# KIRKLEES METROPOLITAN COUNCIL INVESTMENT & REGENERATION SERVICE

### DELEGATED DECISION TO DETERMINE APPLICATIONS FOR CONSENT, AGREEMENT OR APPROVAL REQUIRED BY CONDITION

<b>Reference No:</b>	2026/44/90205/E
<b>Site Address:</b>	Birkenshaw Liberal Club, 10, Croft Street, Birkenshaw, BD11 2HT
<b>Description:</b>	Discharge of details reserved by conditions 16 (LMMP), 17 (cycle storage), 18 (pedestrian link), 20 (surface water strategy), 28 (retaining walls), 29 (highway drainage structure), 30 (temporary drainage) on previous permission 2024/91853 for erection of 21 dwellings with garages, formation of adoptable road, private road and parking spaces and new car park and beer garden for the Liberal Club
<b>Recommending Officer:</b>	Katie Chew

**Proposal:** Discharge of details reserved by conditions 16 (LMMP), 17 (cycle storage), 18 (pedestrian link), 20 (surface water strategy), 28 (retaining walls), 29 (highway drainage structure), 30 (temporary drainage) on previous permission 2024/91853 for erection of 21 dwellings with garages, formation of adoptable road, private road and parking spaces and new car park and beer garden for the Liberal Club.

PLAN ON PLOT 18 RETAINING WALL
SCALE 1:100

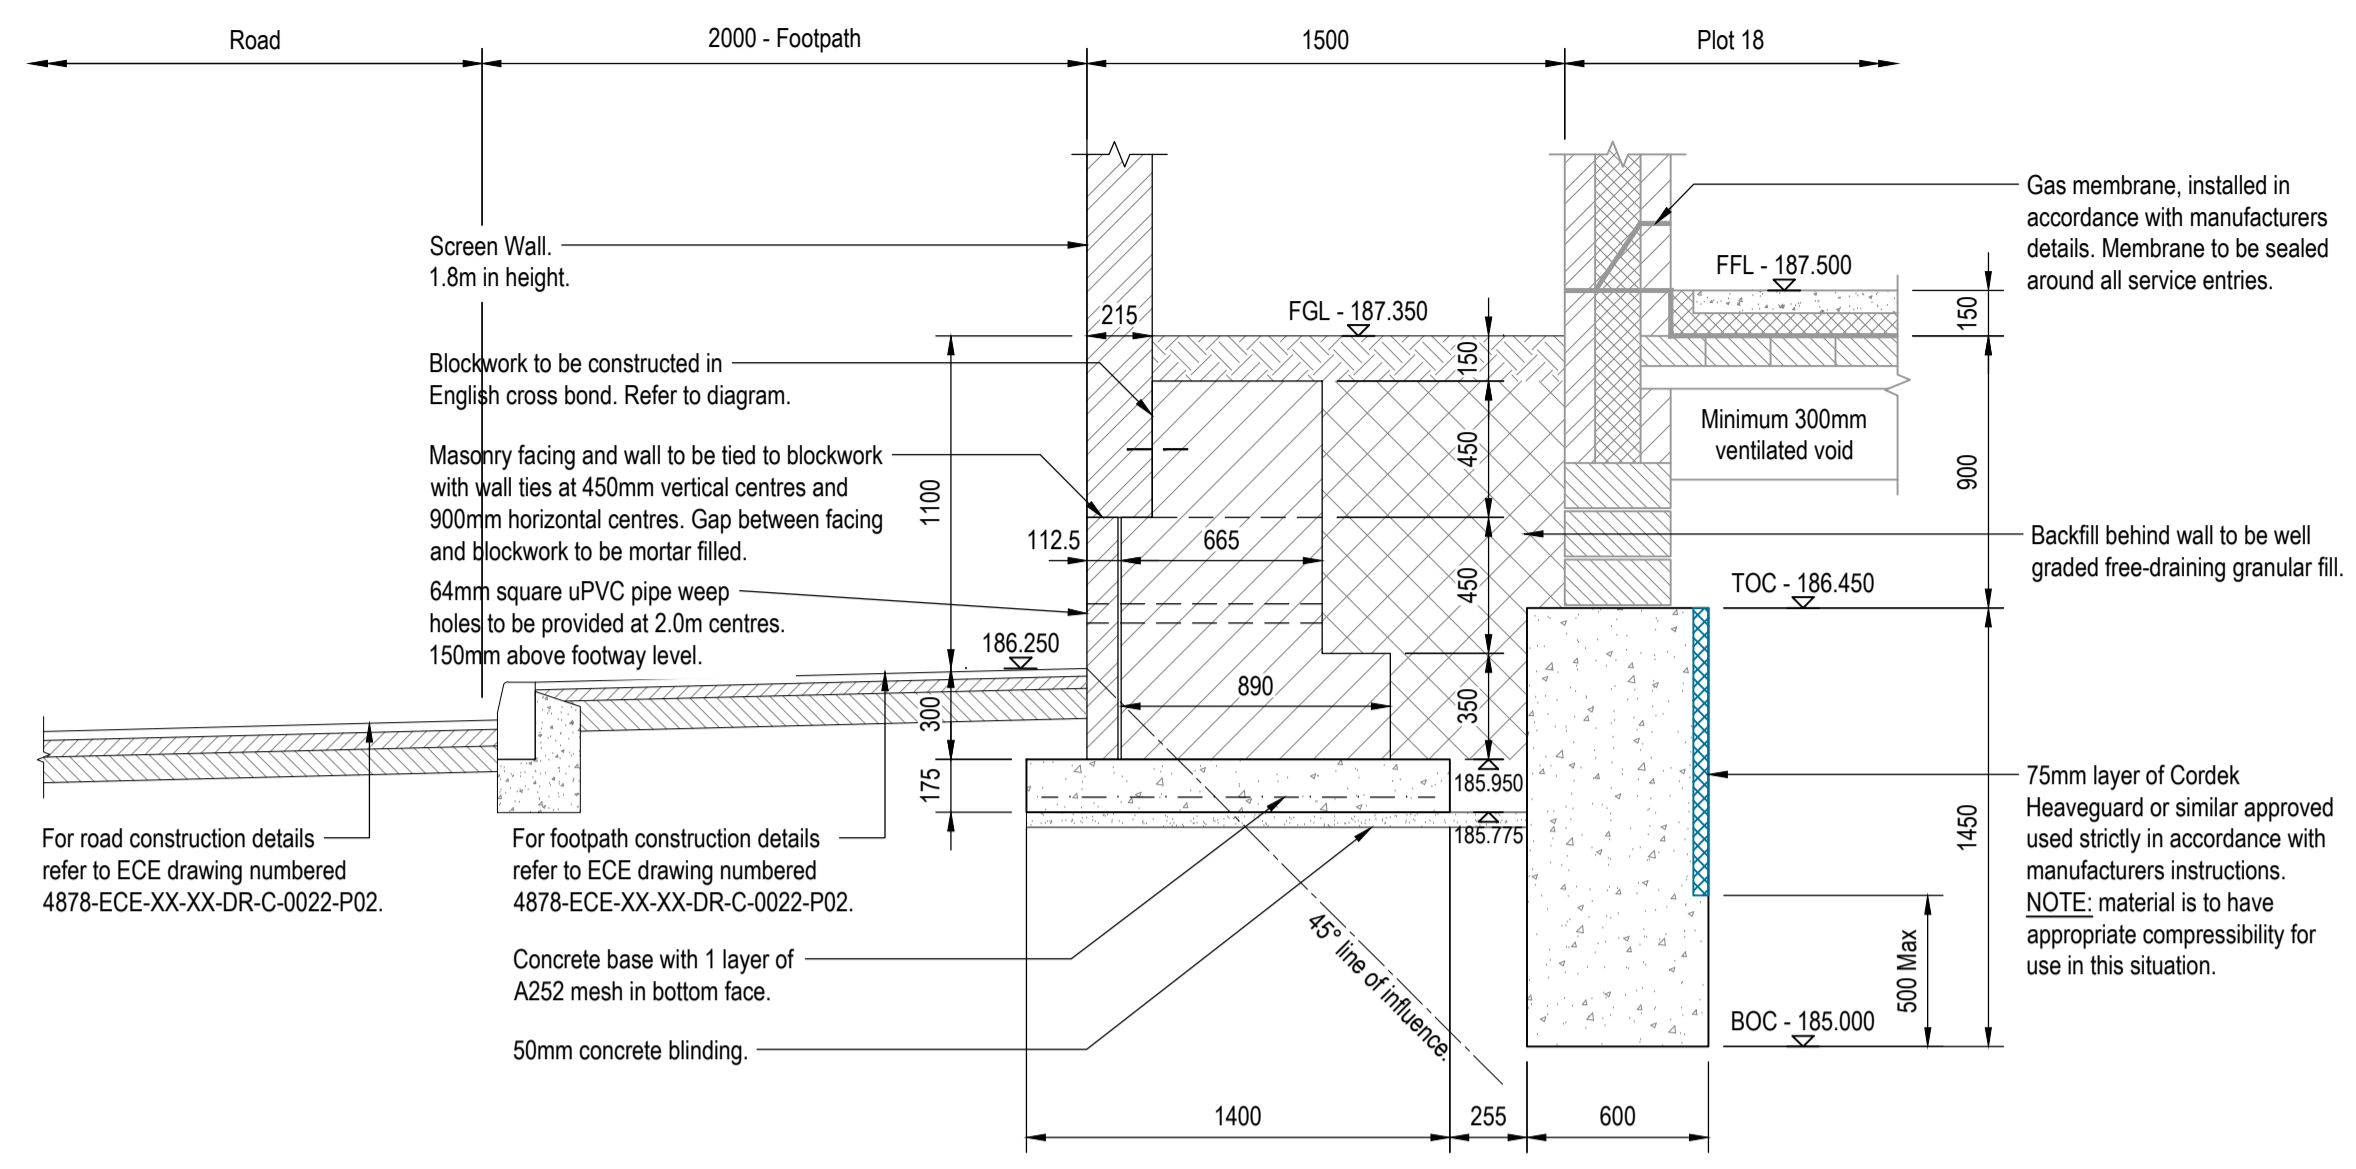
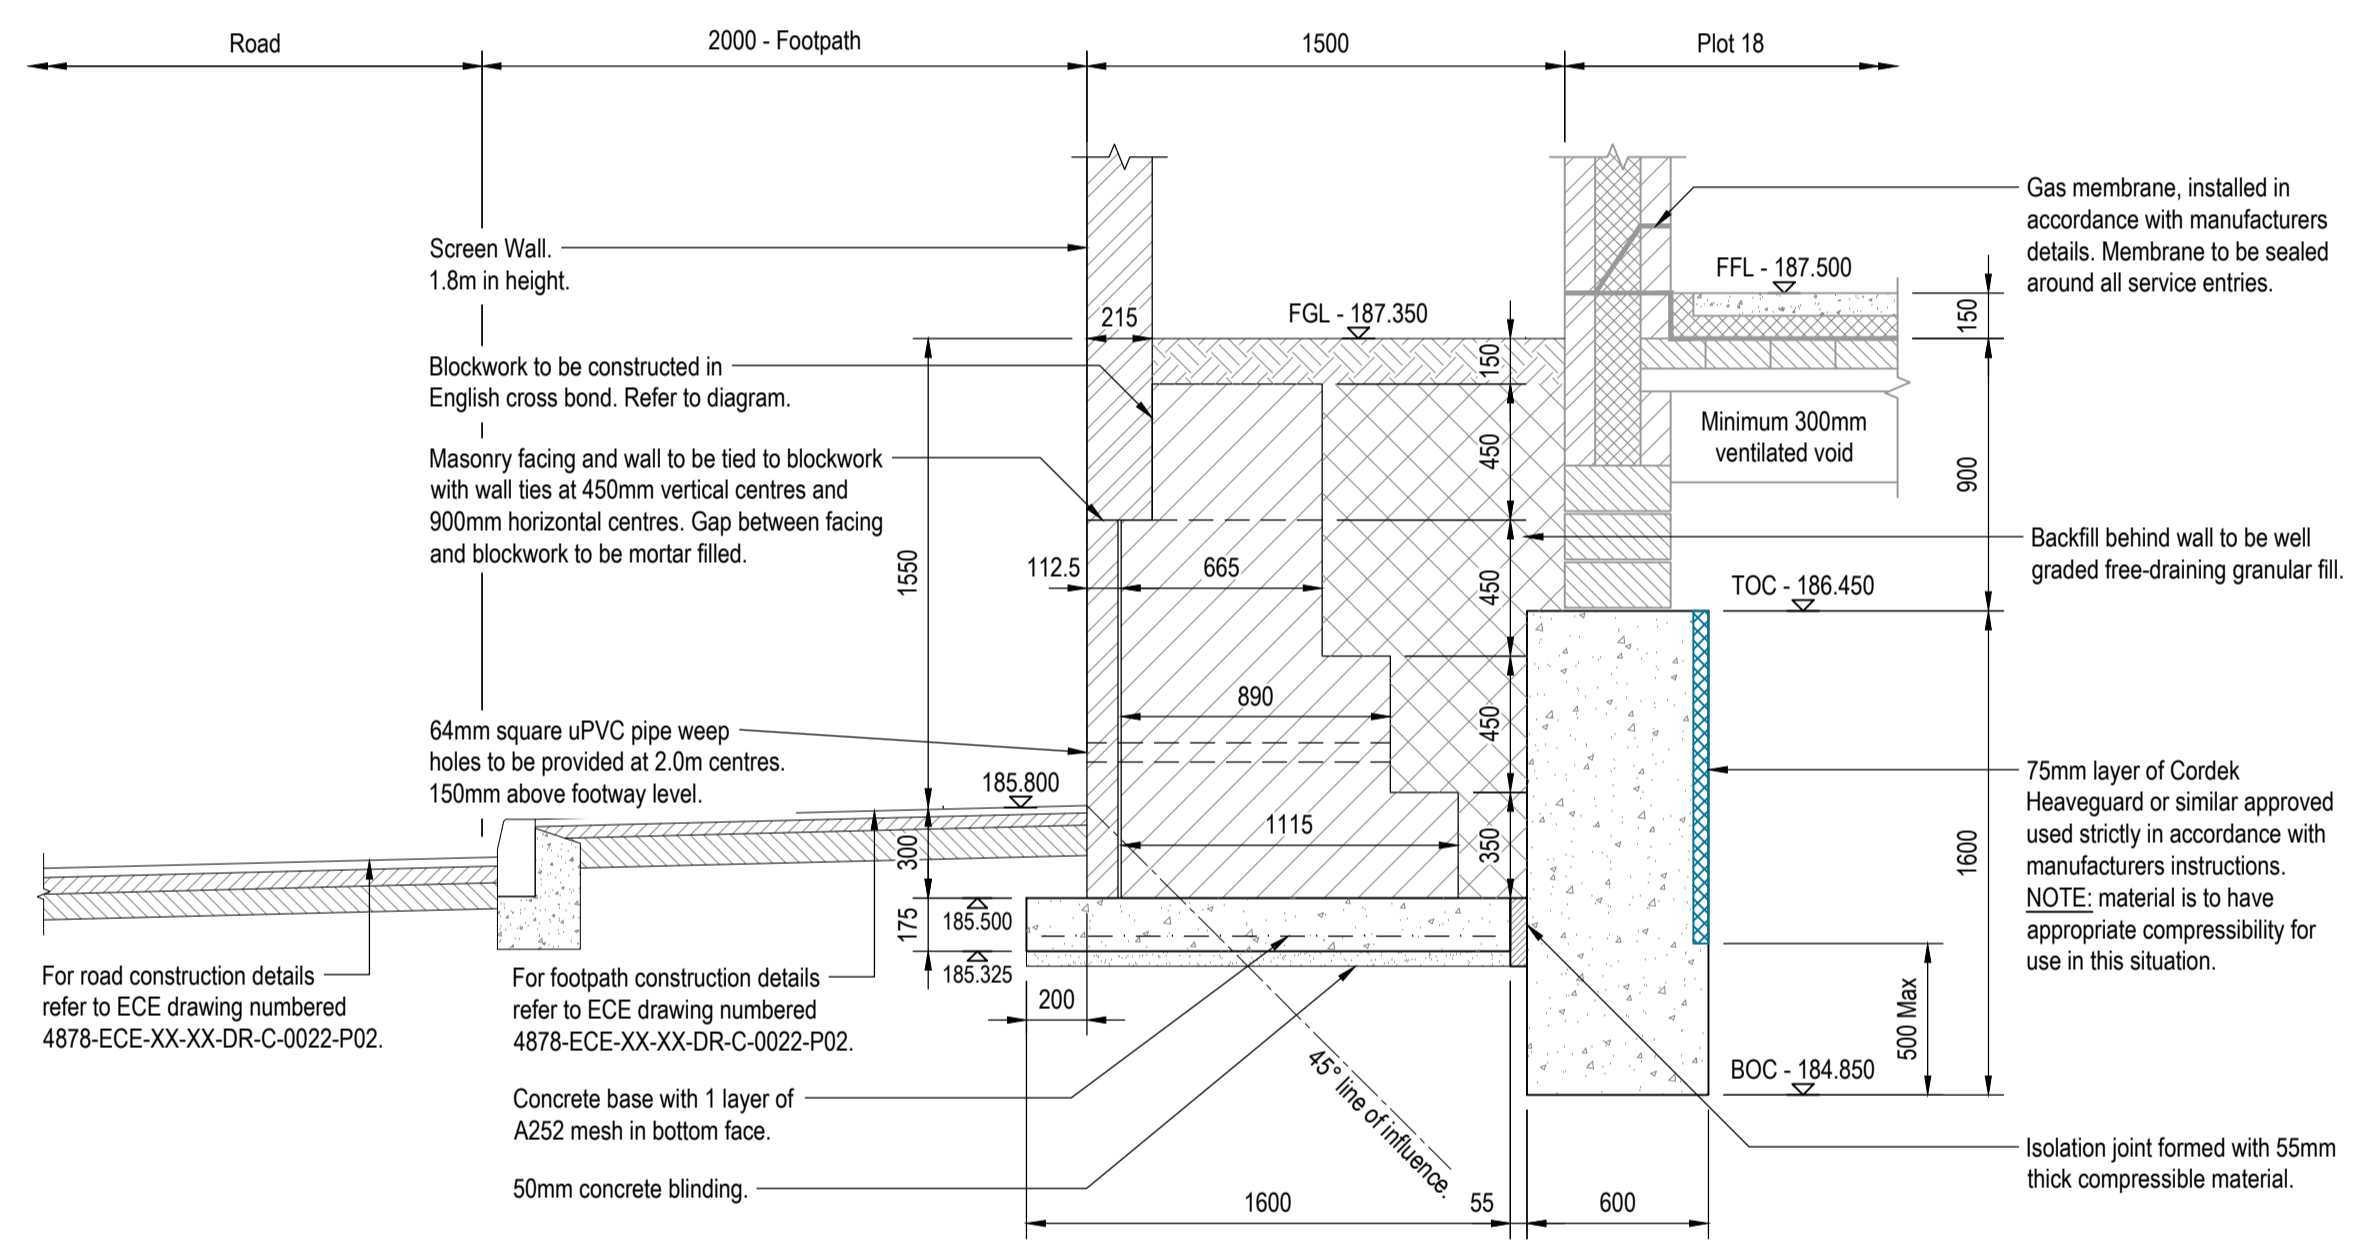
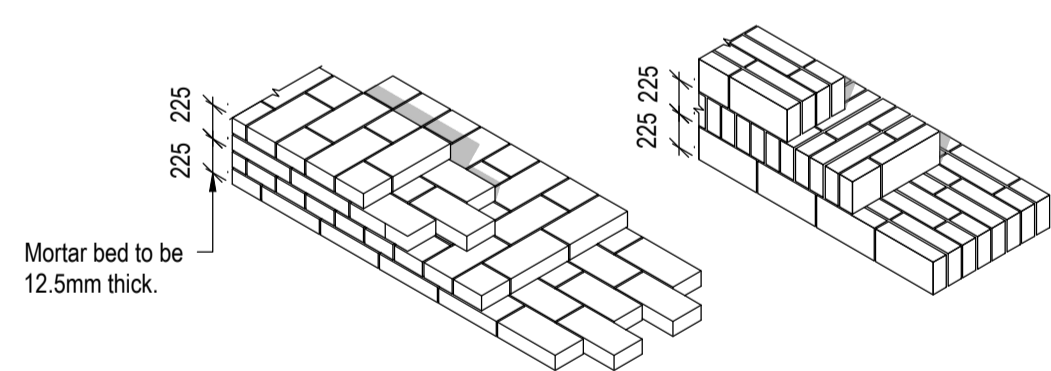
*This condition cannot be discharged pending the satisfactory conclusion of the technical approval process for the design of proposed retaining walls at this site, which is ongoing.*

Following receipt of the above, the applicant sought to submit several amended drawings and additional information of which KC Highways Structures confirmed via email on the 12/05/2026 that the AIP Rev 04 has now been signed for the design of the proposed private masonry faced gravity retaining wall, adjacent to Plot 18. KC Highways Structures also note that the applicant will need to arrange for the submission of satisfactory structural calculations together with a Design & Check Certificate for this structure in compliance with the approved AIP Rev 04, so as to enable the conditional conclusion of the technical approval process. Alongside, the submission of a “Construction Compliance Certificate” including “As Built” drawings in accordance with CG 300 upon the completion of the works.

A note regarding the need to submit the requested satisfactory structural calculations together with a Design & Check Certificate, and “*Construction Compliance Certificate*” and “*As Built*” drawings directly to KC Highway Structures is also recommended.
